18 December 2023

Section 73 Planning Application: Alterations and extensions, new buildings and landscaping scheme (variation of condition 2 of Planning Permission 22/00767/HHD to allow minor changes to the approved scheme).

Listed Building Consent Application: Internal and external alterations comprising demolition works, extensions, new buildings and landscaping scheme (amendments to 22/0779/LBC).

Wootton Place, Church Street, Wootton, Woodstock, OX20 1EA

Project Wootton Place	
Client C/O JPPC	
Drawing Title Proposed Plant Enclosure Elevations	
Scale 1:100	Date Created 08/08/23

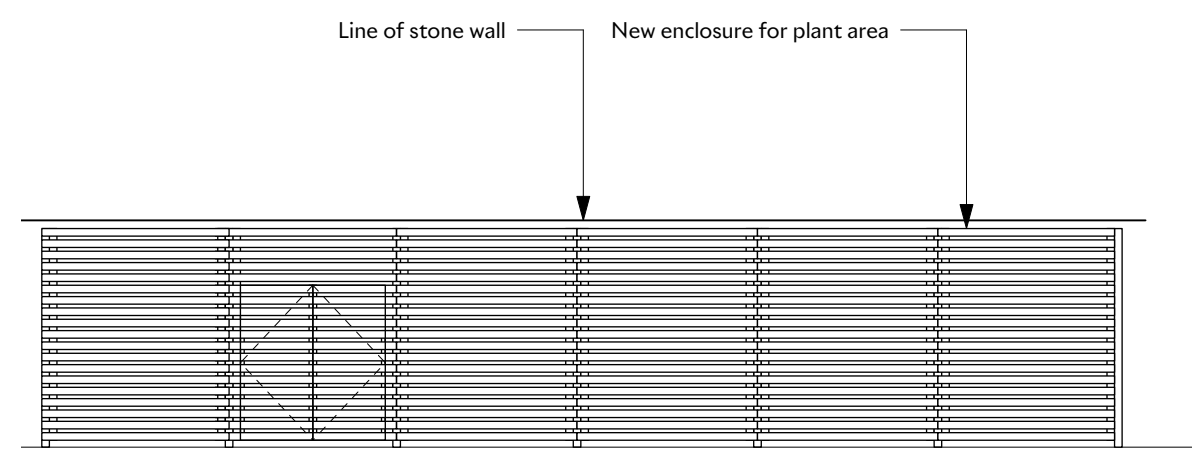
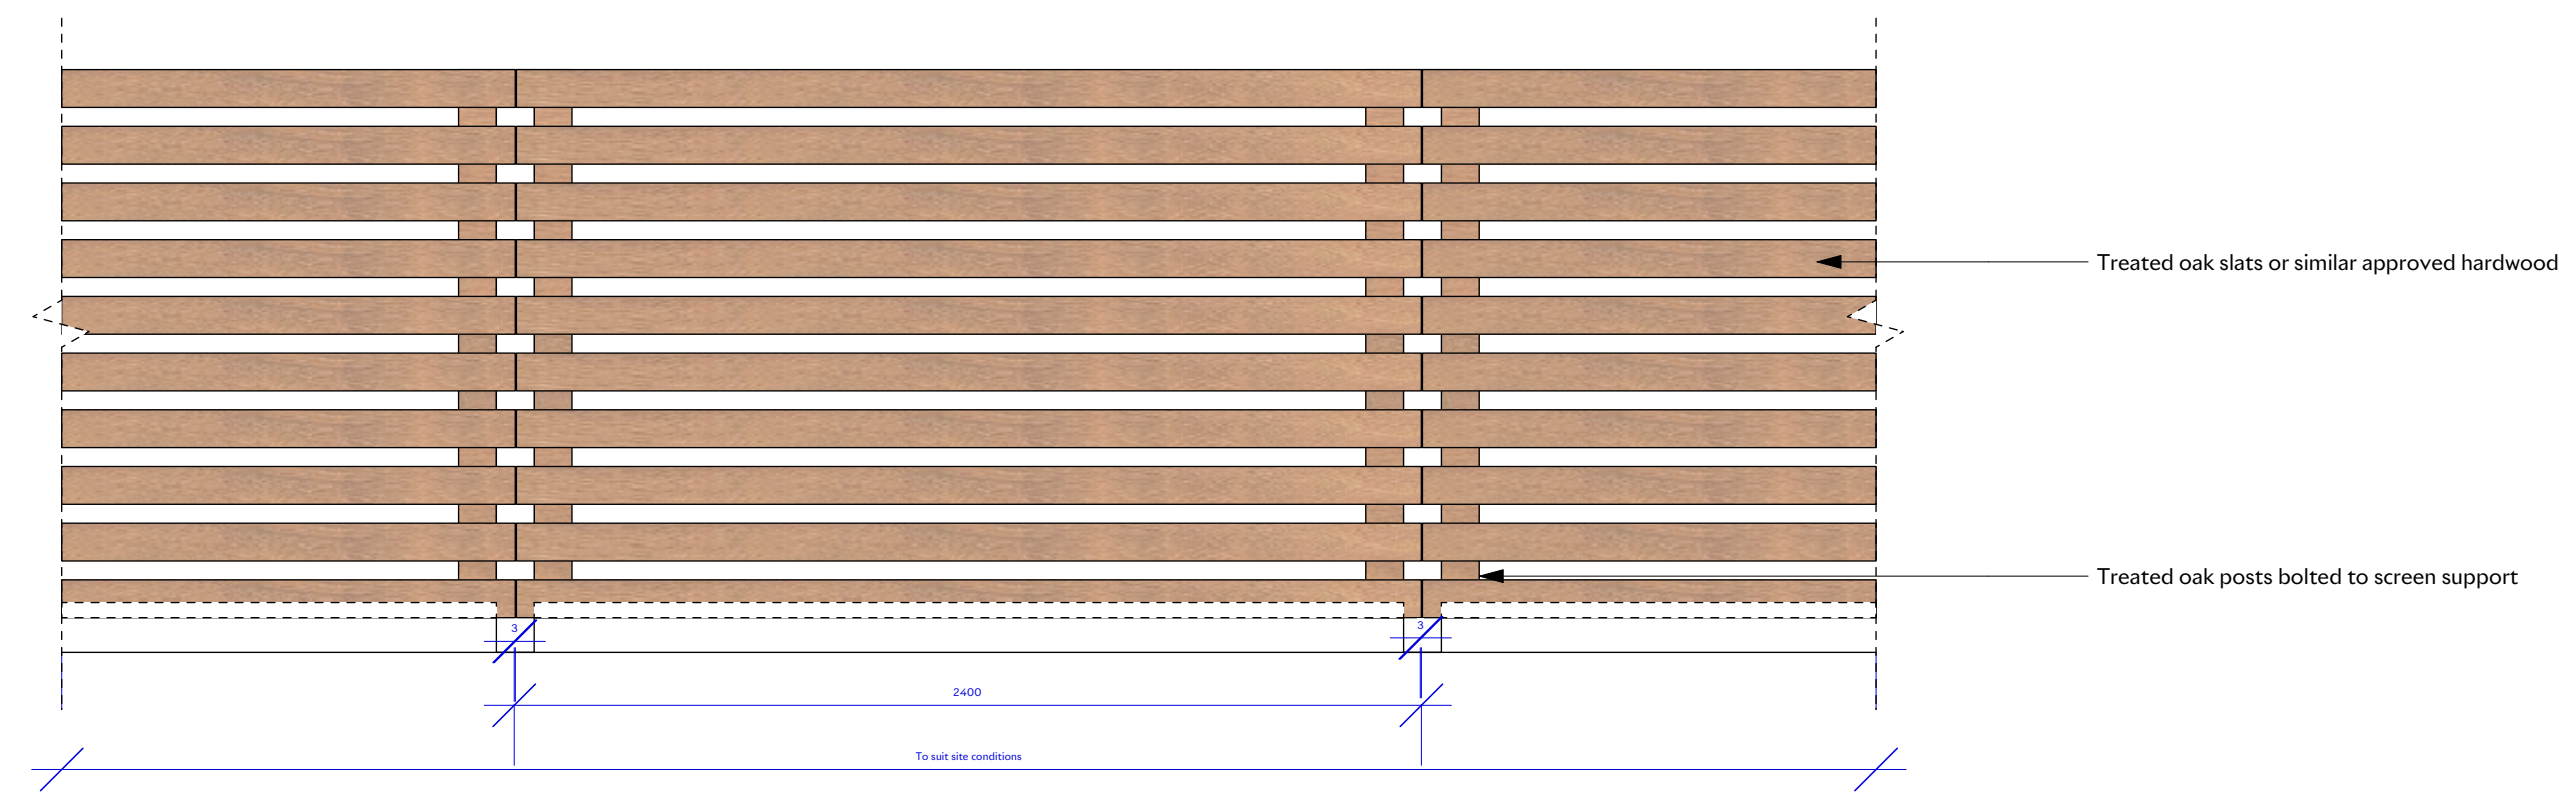
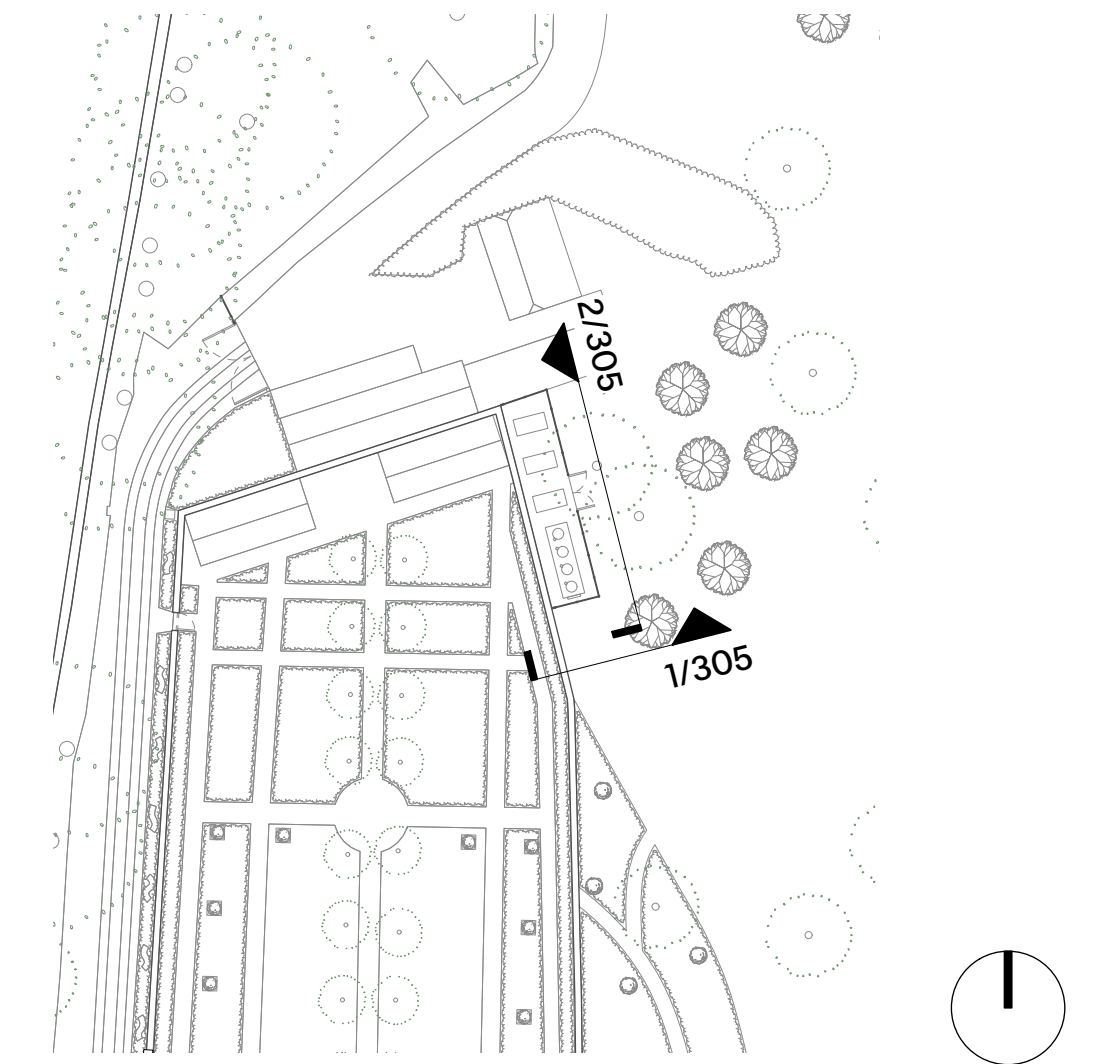
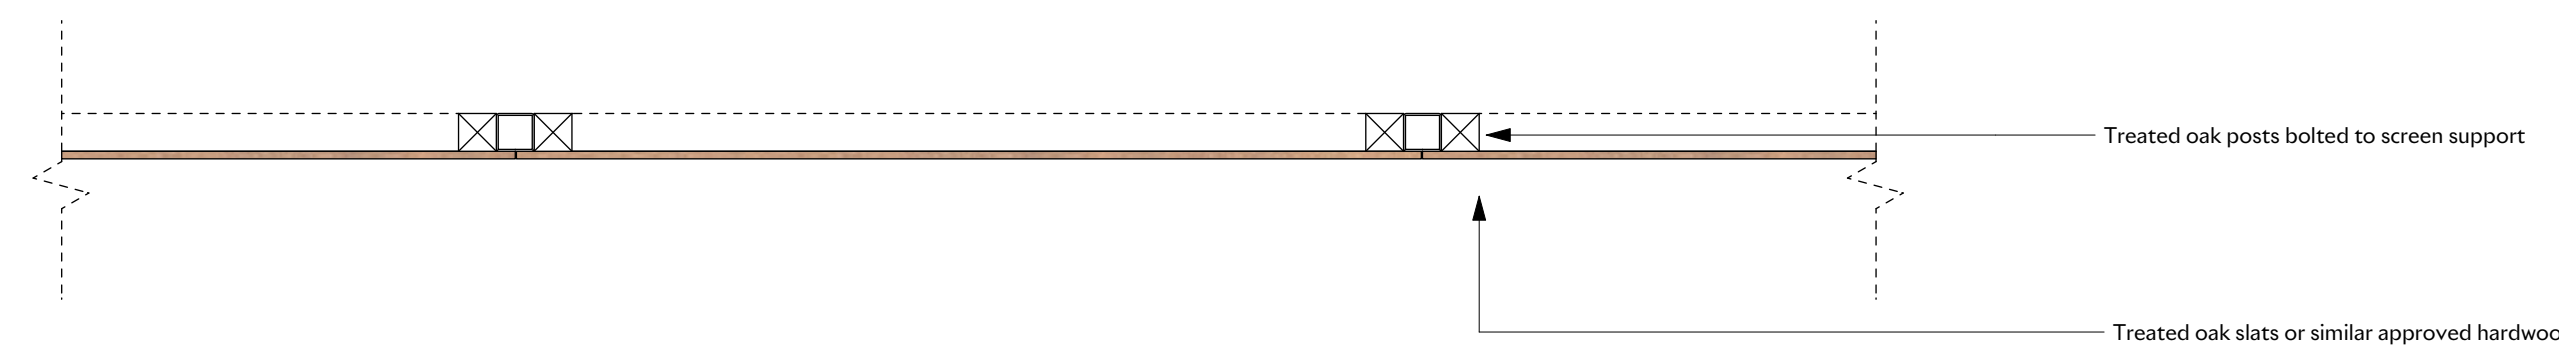
- *Introduction of an external plant area to house ASHP towards the north of the site.*
- *Amendments to the approved landscaping scheme.*

Gym/Wellness Proposed Elevations & Section

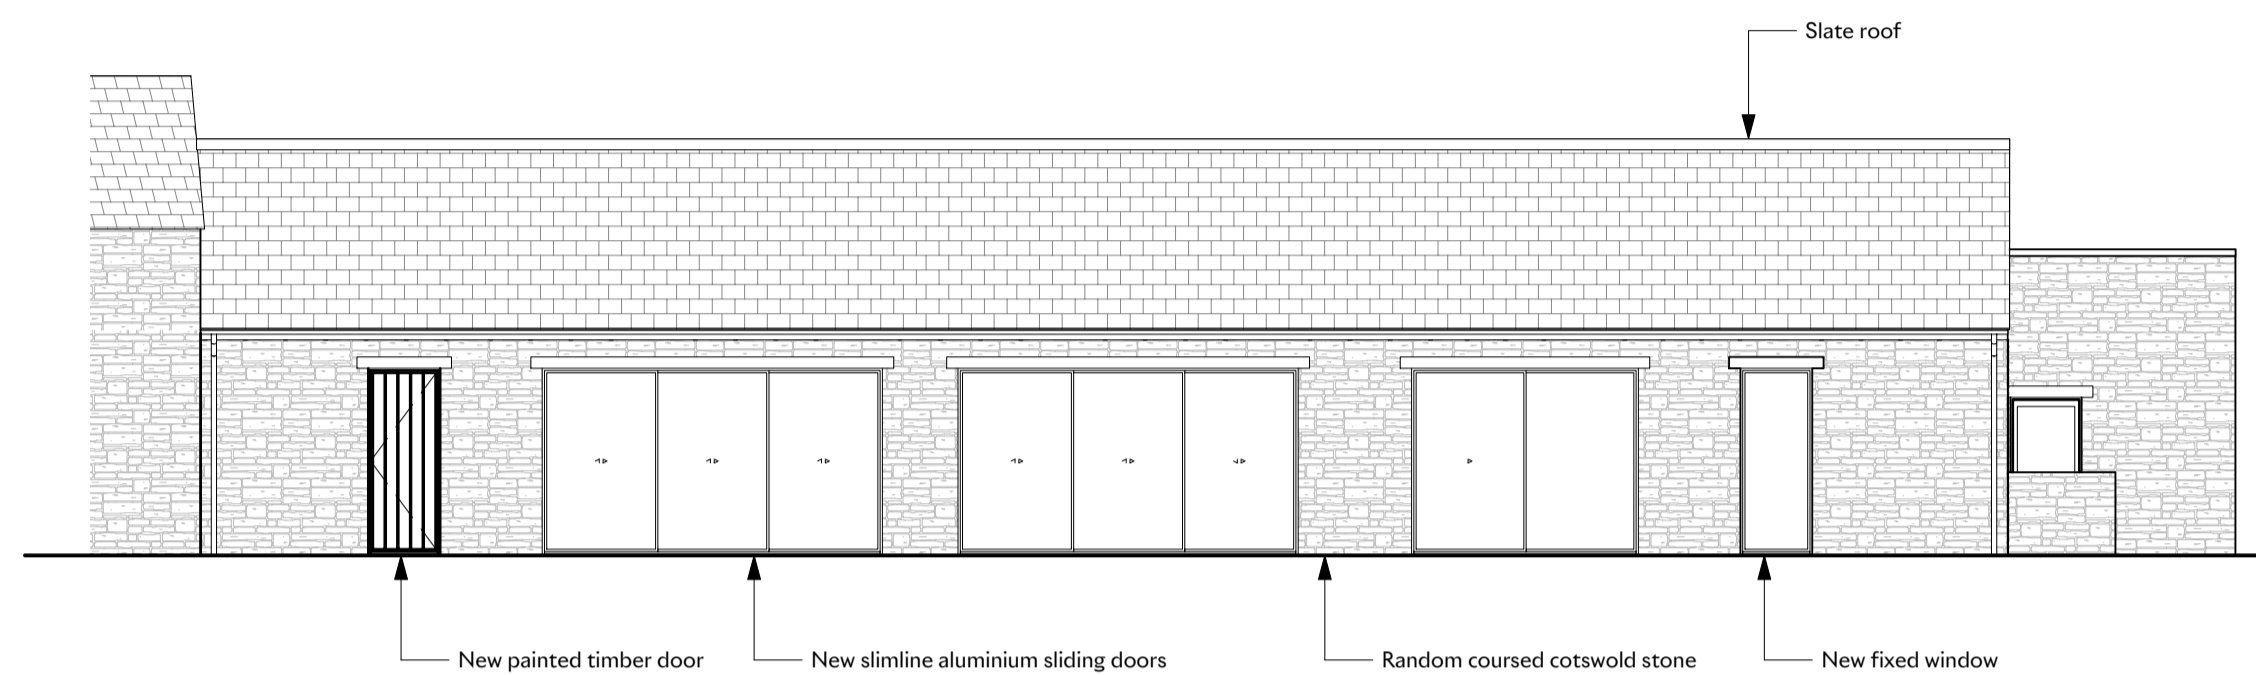
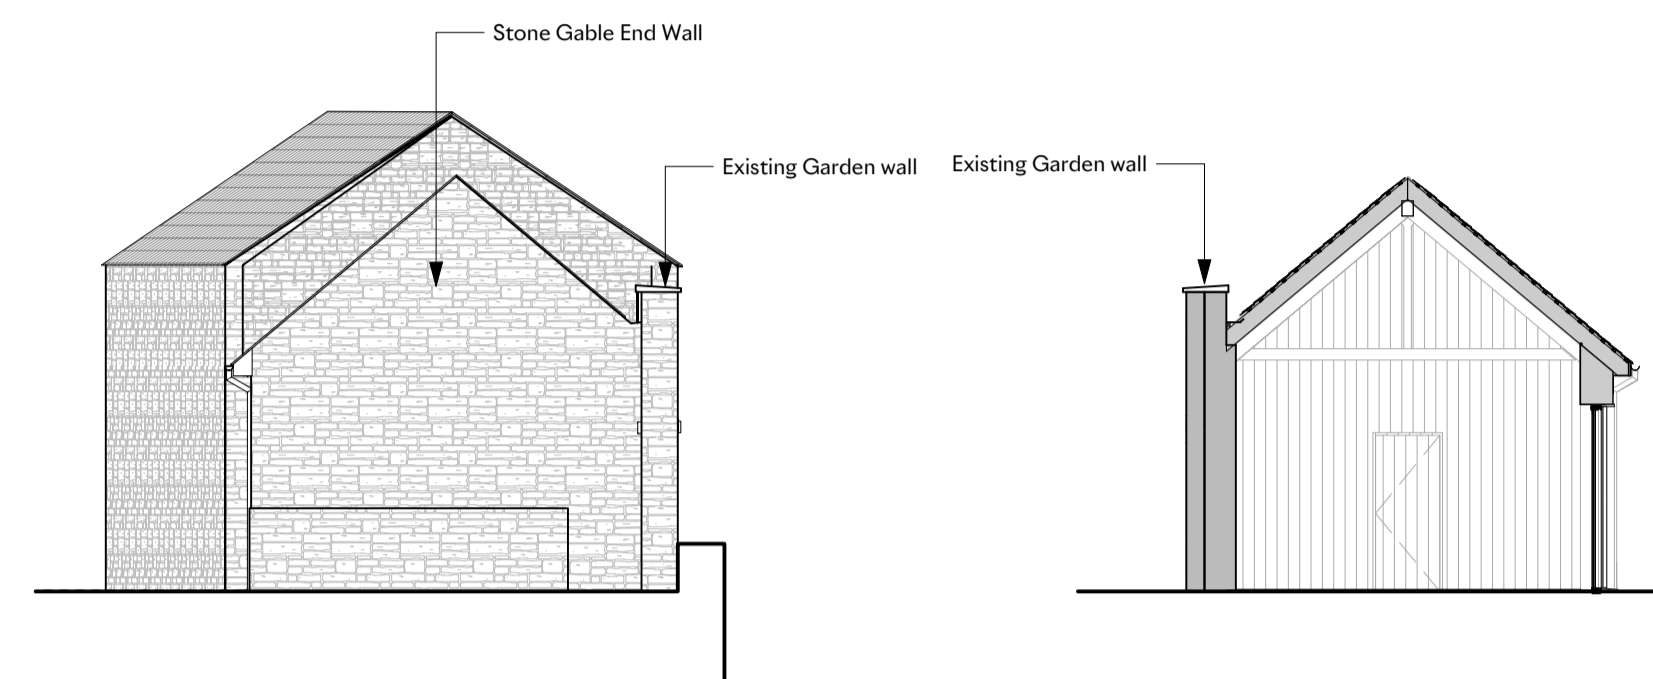
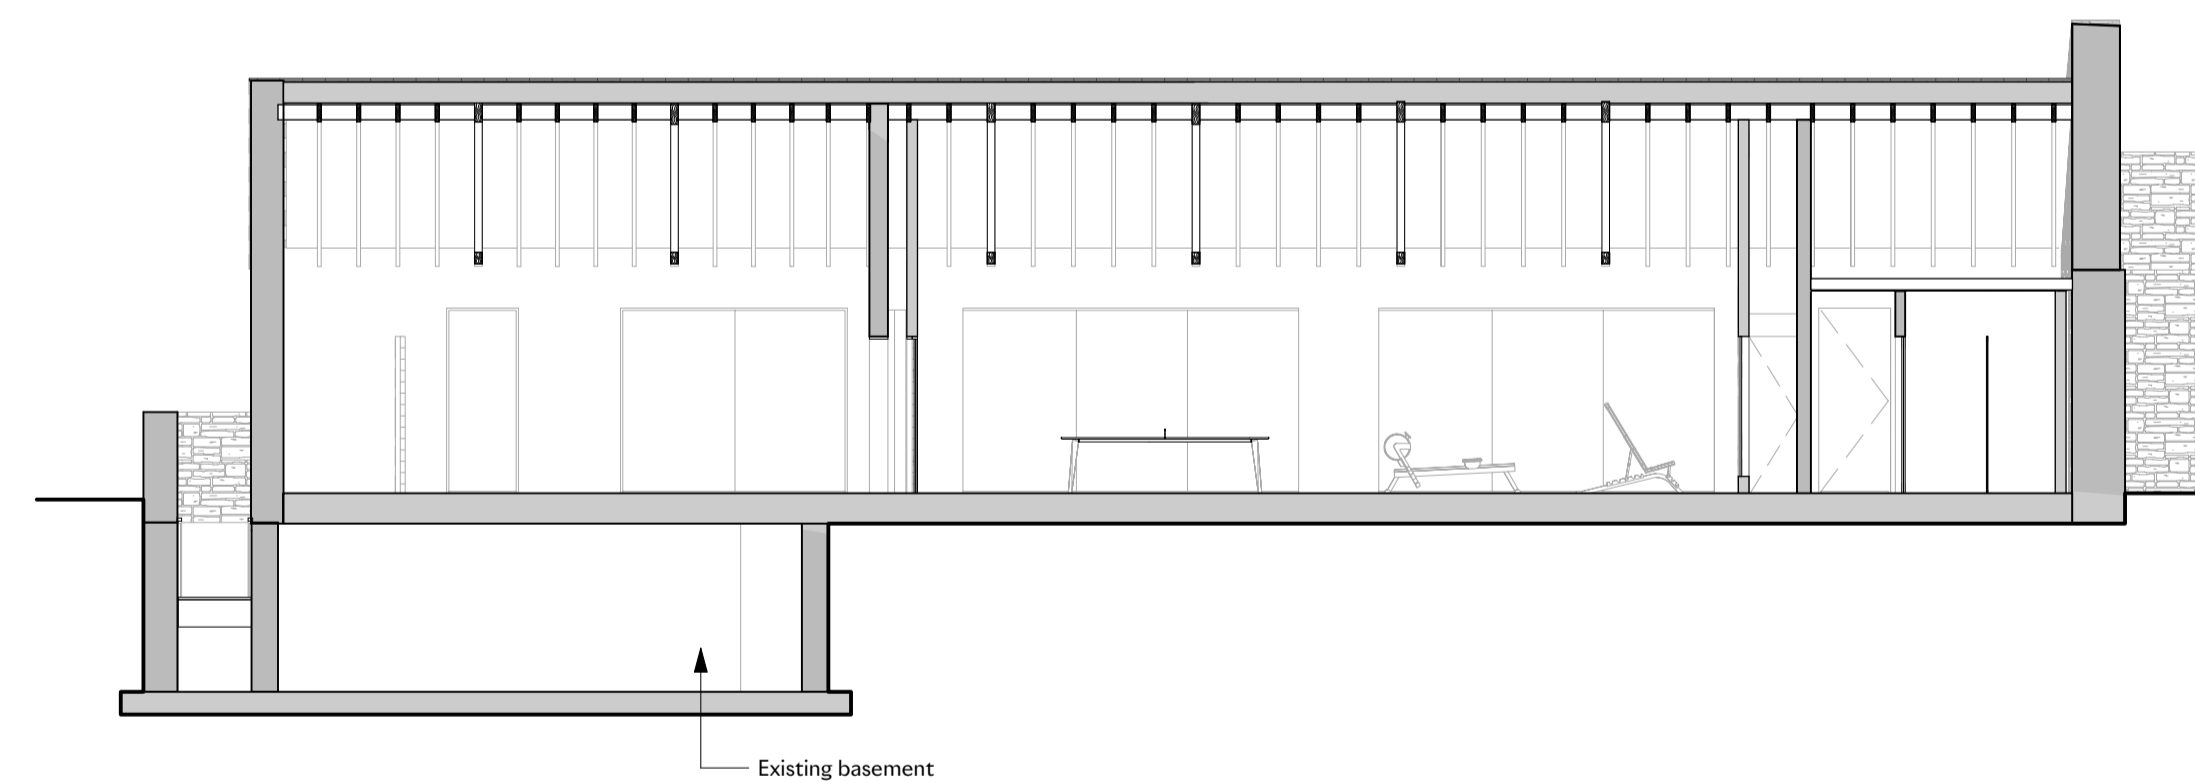
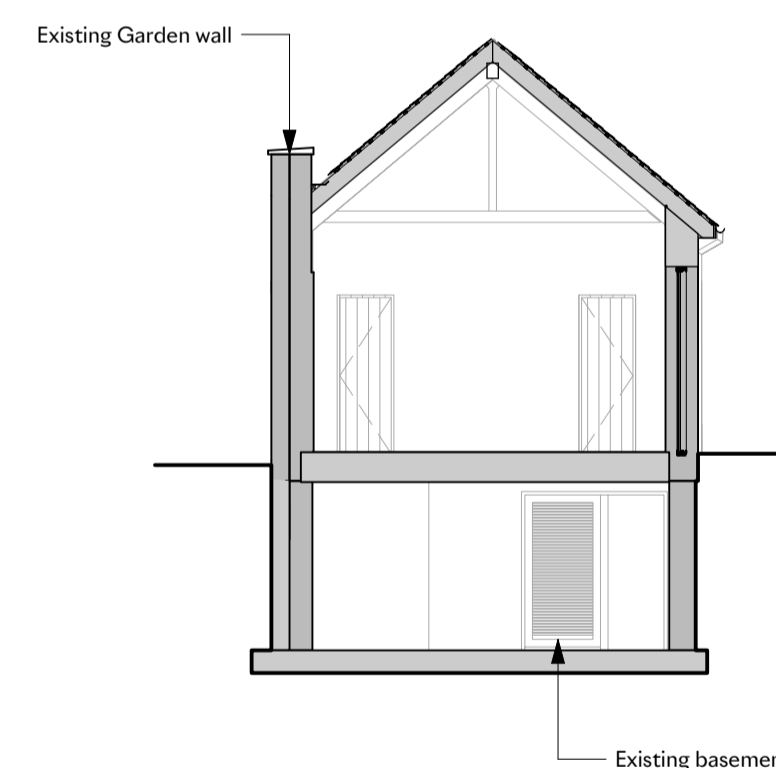
- *Minor reconfiguring of internal spaces within the gym.*
- *Insertion of a new door and window in the front elevation.*

Project Wootton Place	
Client C/O JPPC	
Drawing Title Proposed Staff Cottage Elevations	
Scale 1:100	Date Created 08/08/23

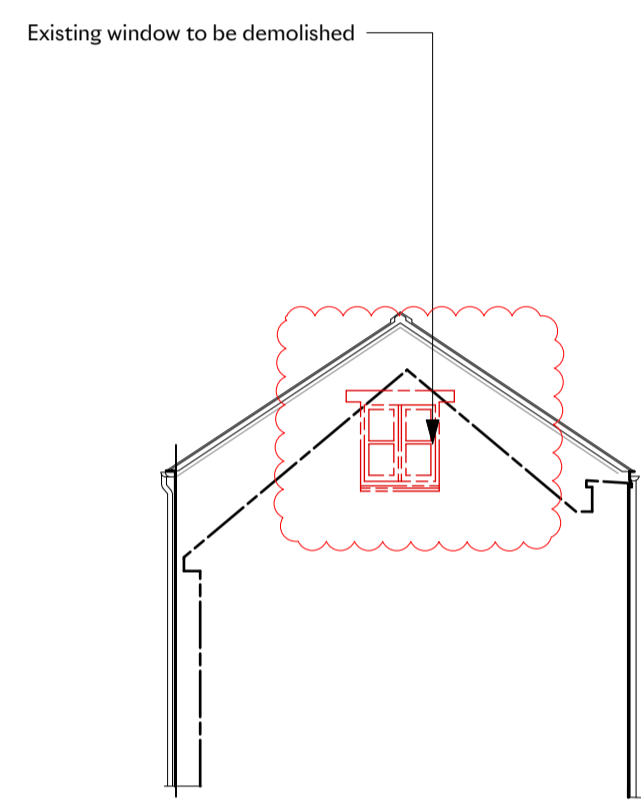
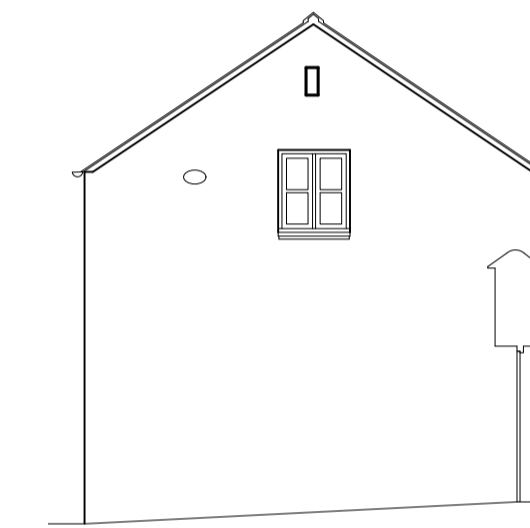
- *Insertion of two metal conservation style rooflights to staff cottage roof.*
- *Blocking up existing window to match existing.*
